PEACEFUL RIDGE AT FOUNTAIN VALLEY SUBDIVISION

RESIDENTIAL SUBDIVISION CONSTRUCTION DRAWINGS

EPC STORMWATER REVIEW COMMENTS ARE SHOWN IN ORANGE BOXES WITH BLACK TEXT

KNUCKLE #3- PANPIPE LANE & BLACK POWDER TRAIL

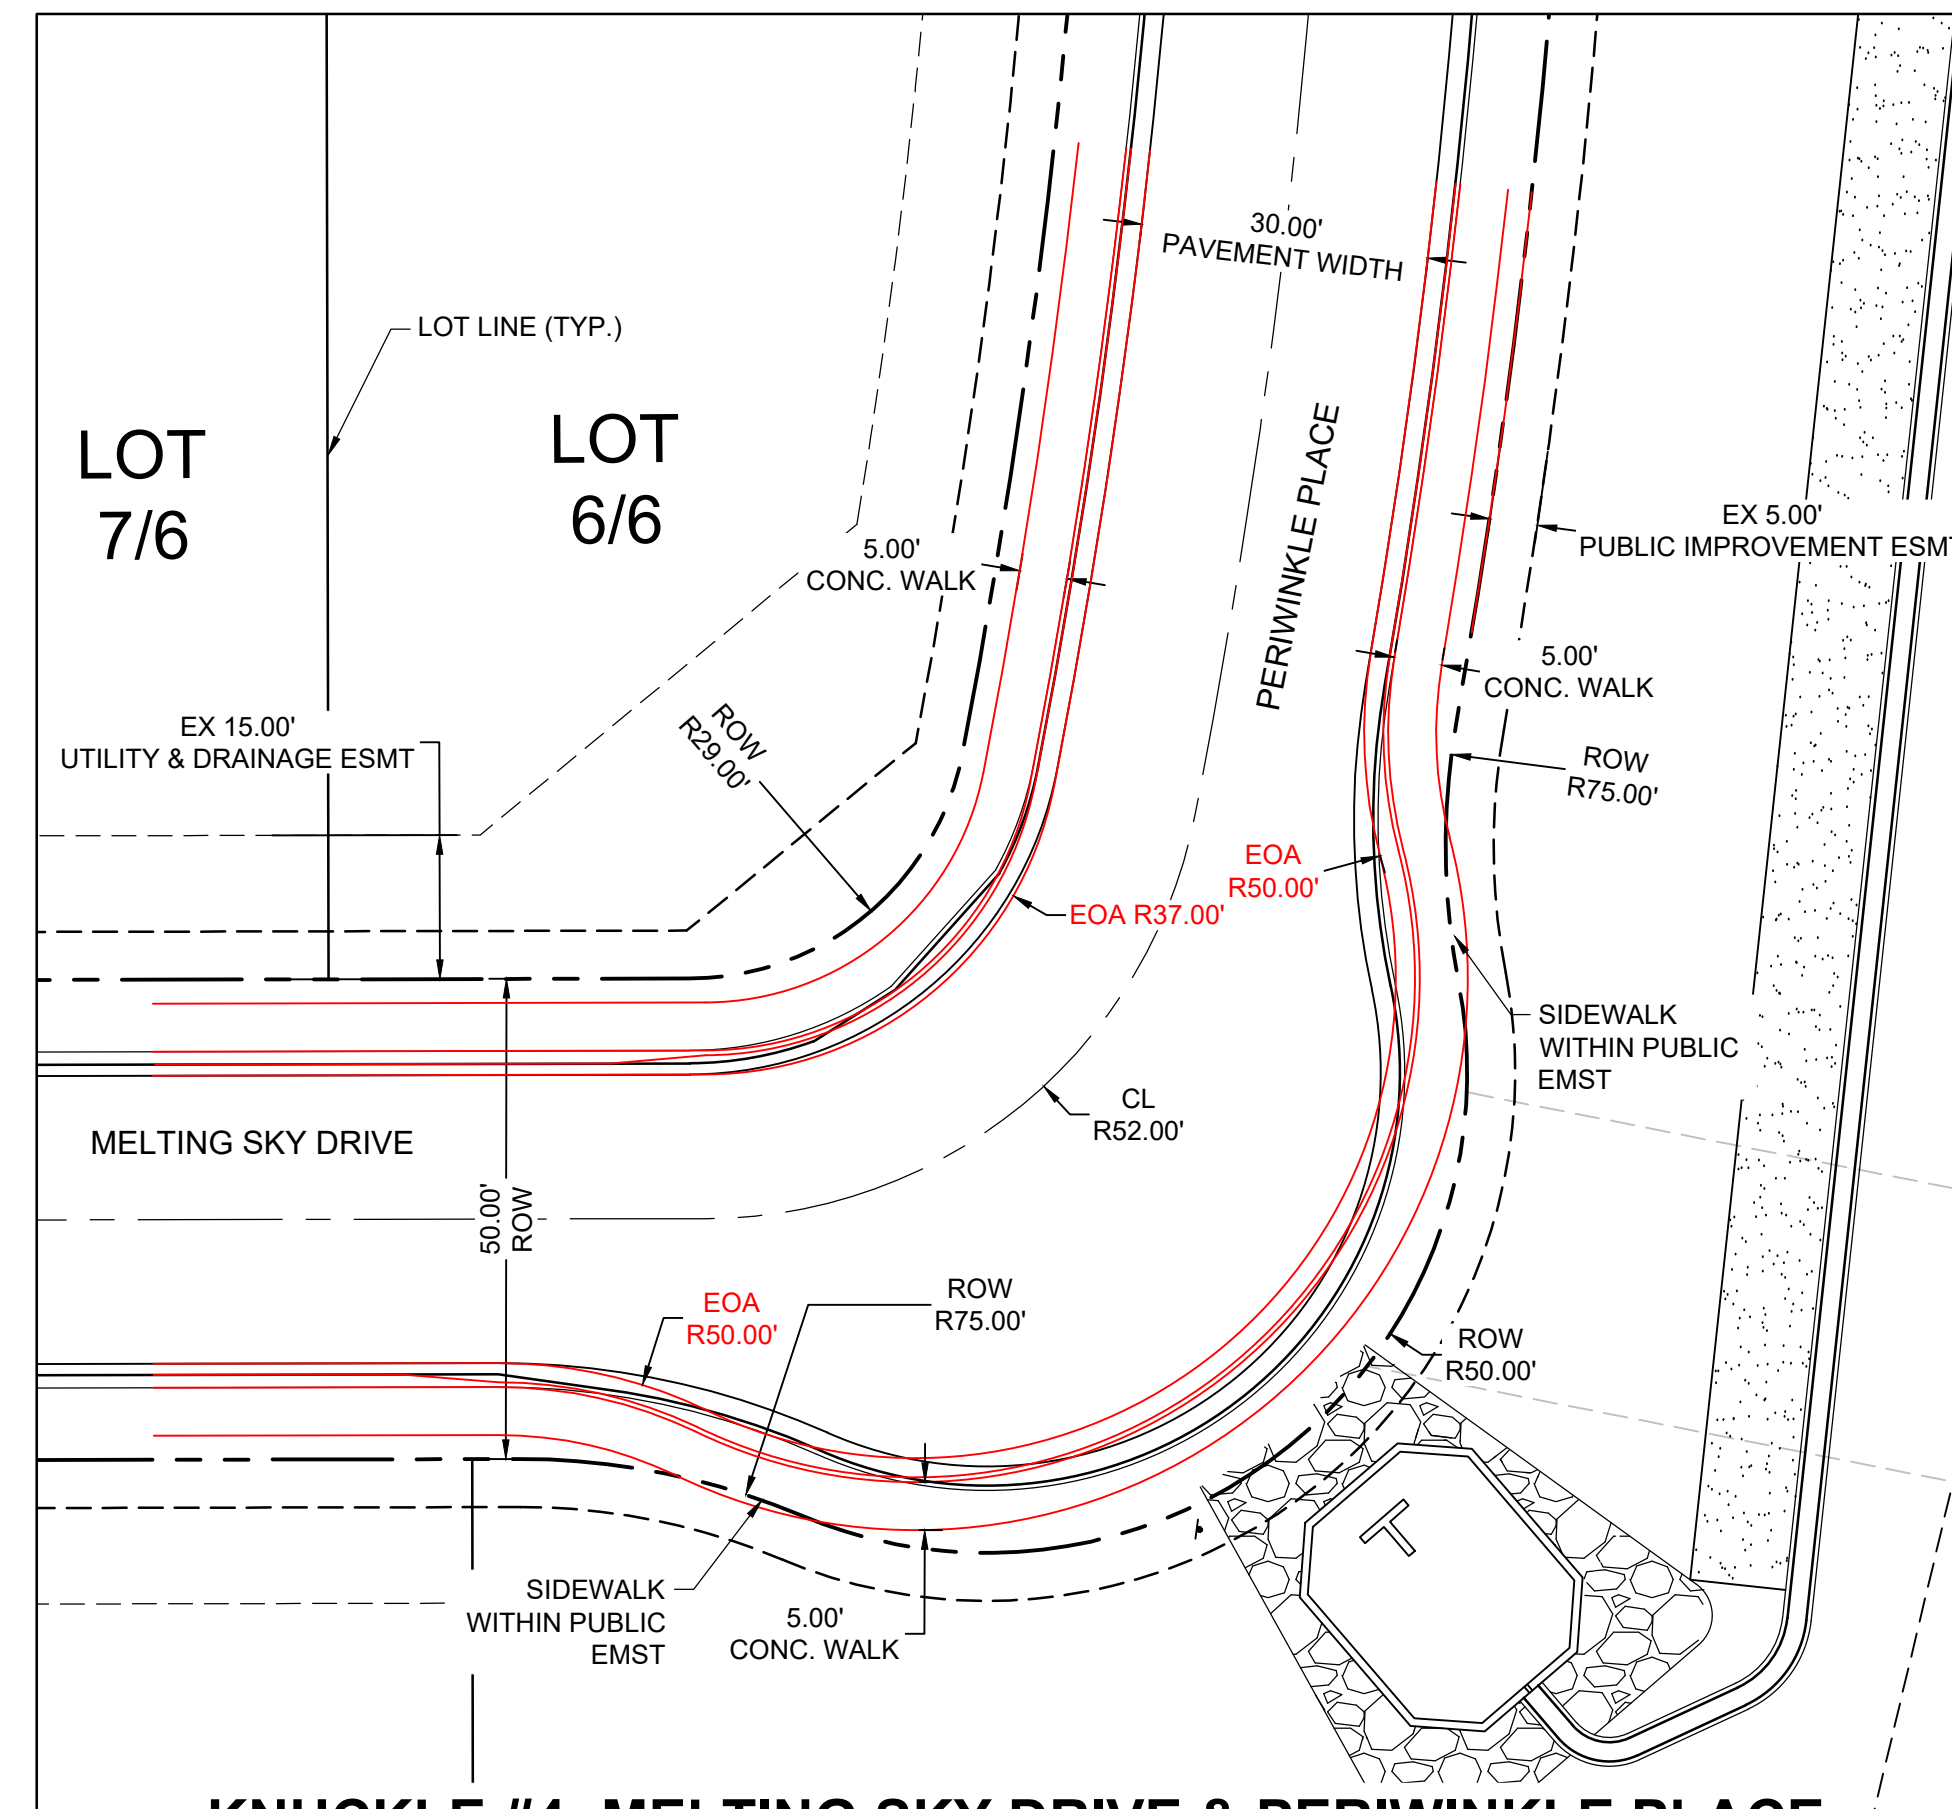
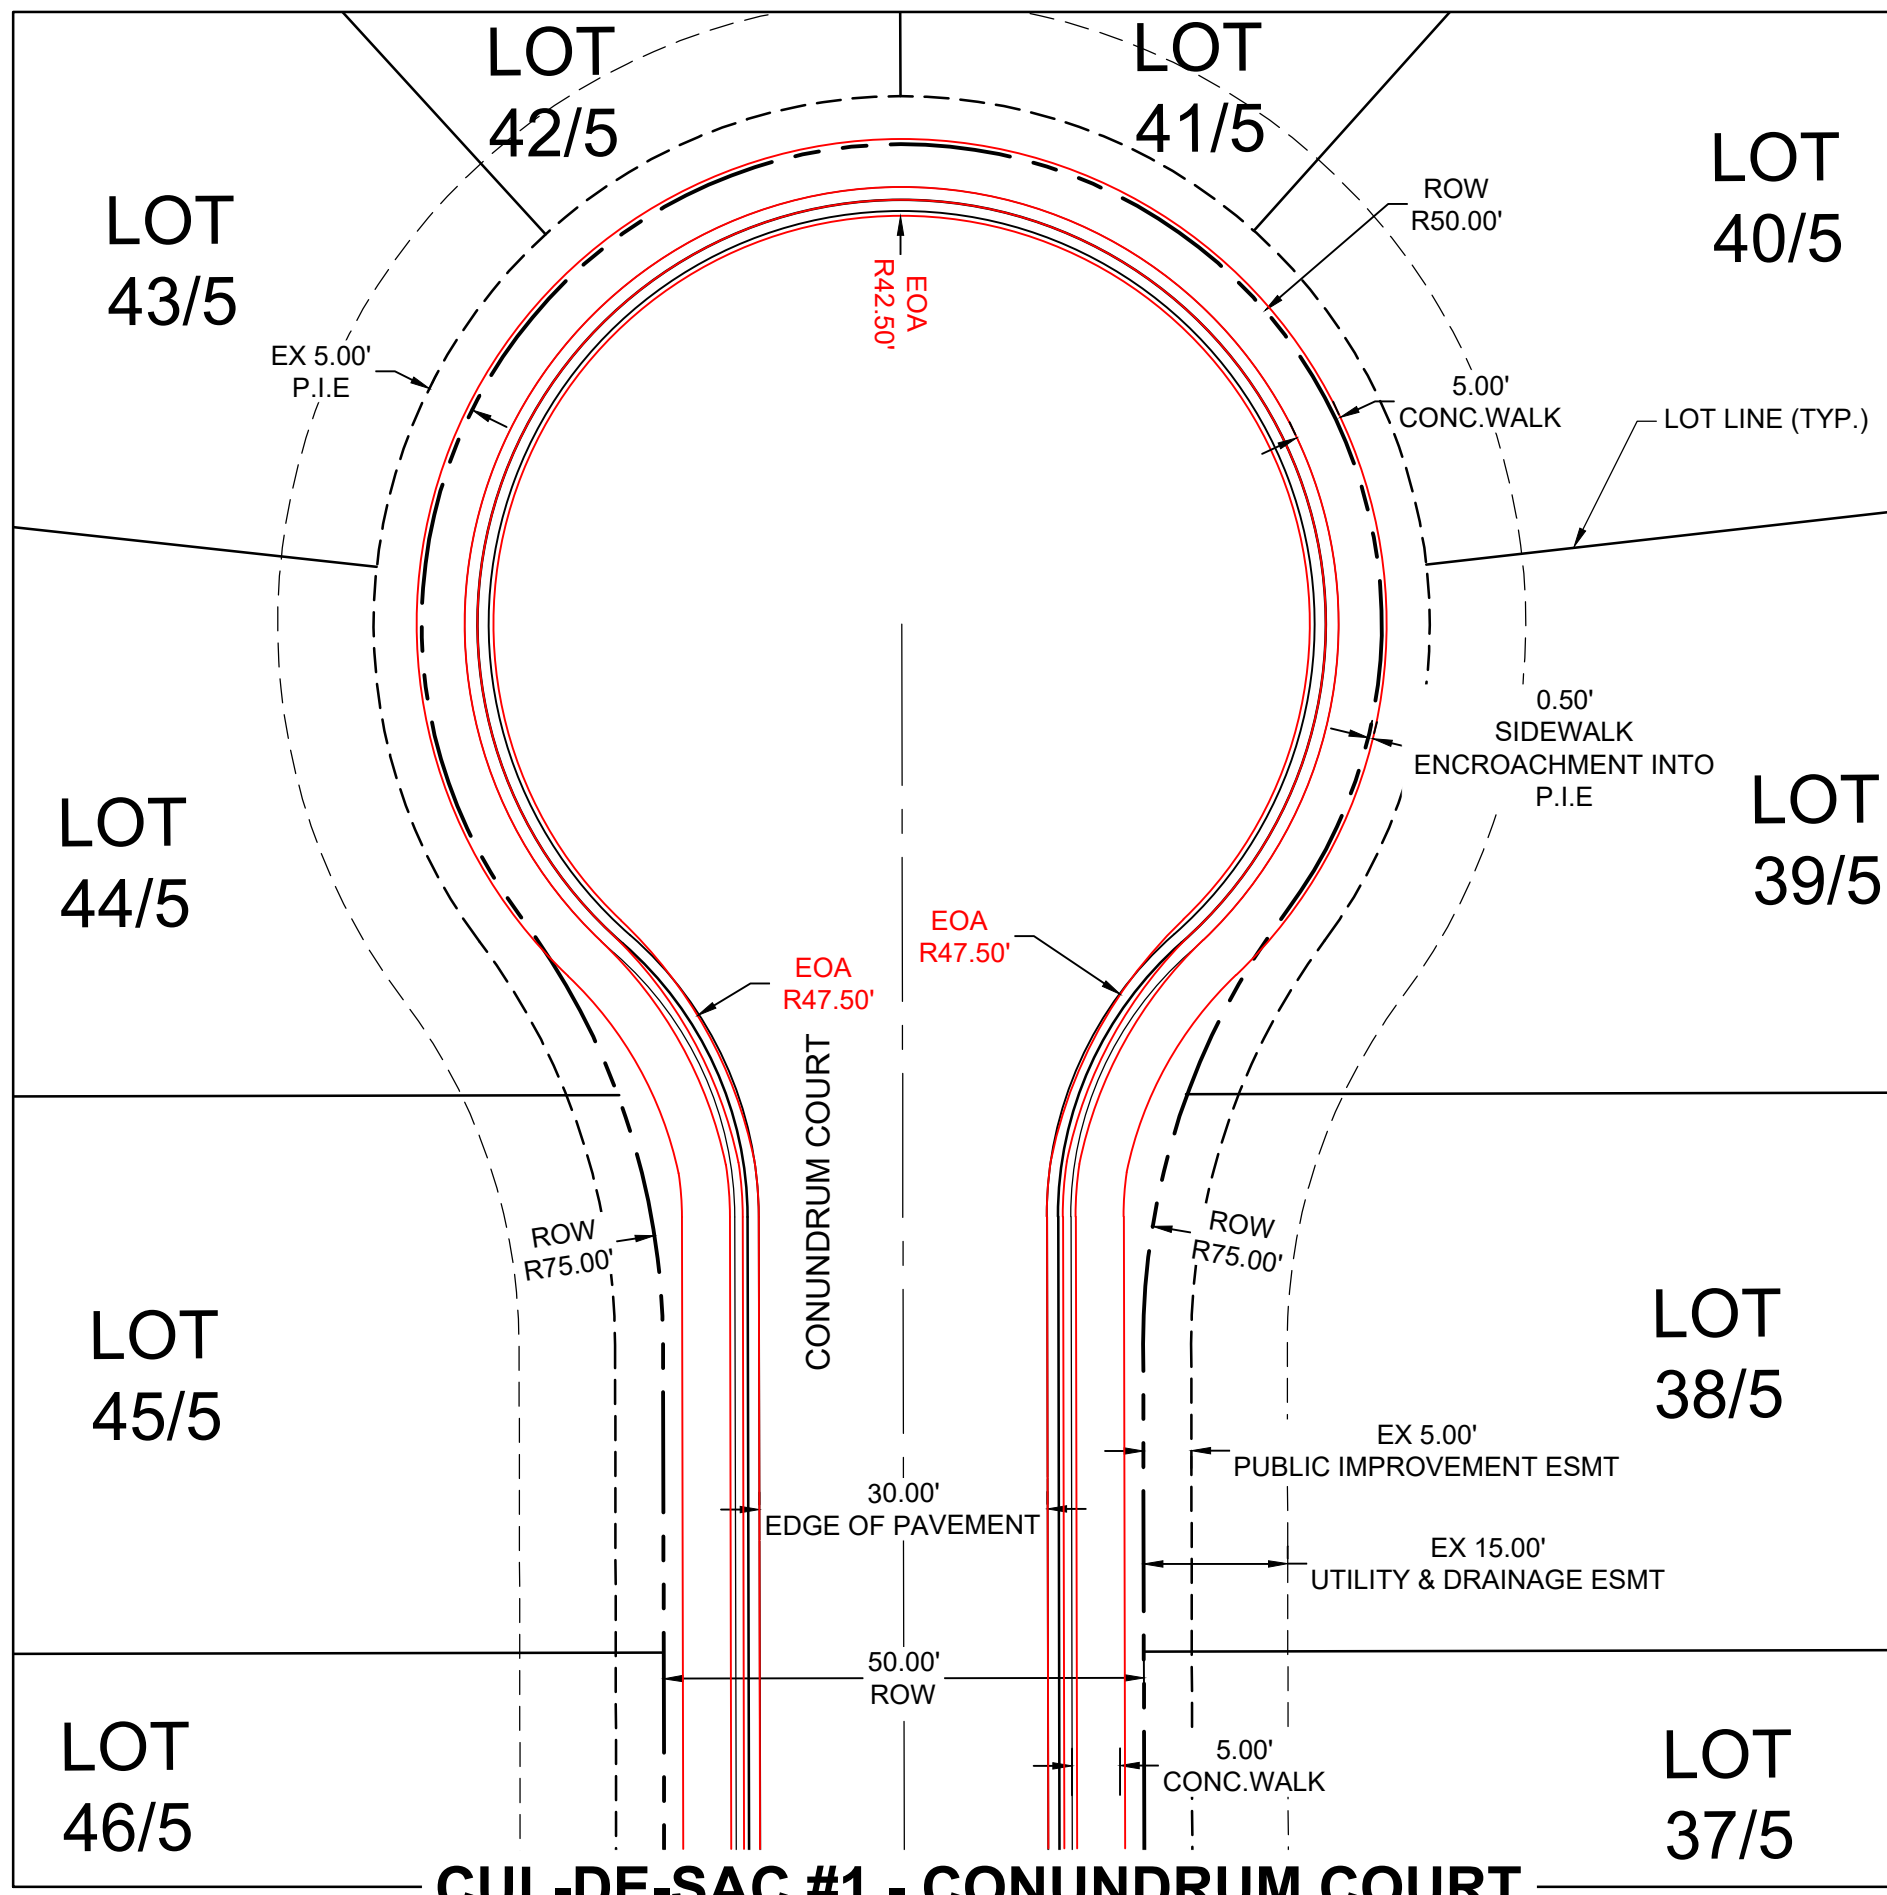
Knuckle designs do not meet EPC SD-2.77, please submit deviation requests for knuckles for documentation.

5D and 5E are not shown in the legend. A deviation request is required for the knuckle design not meeting ECM criteria.
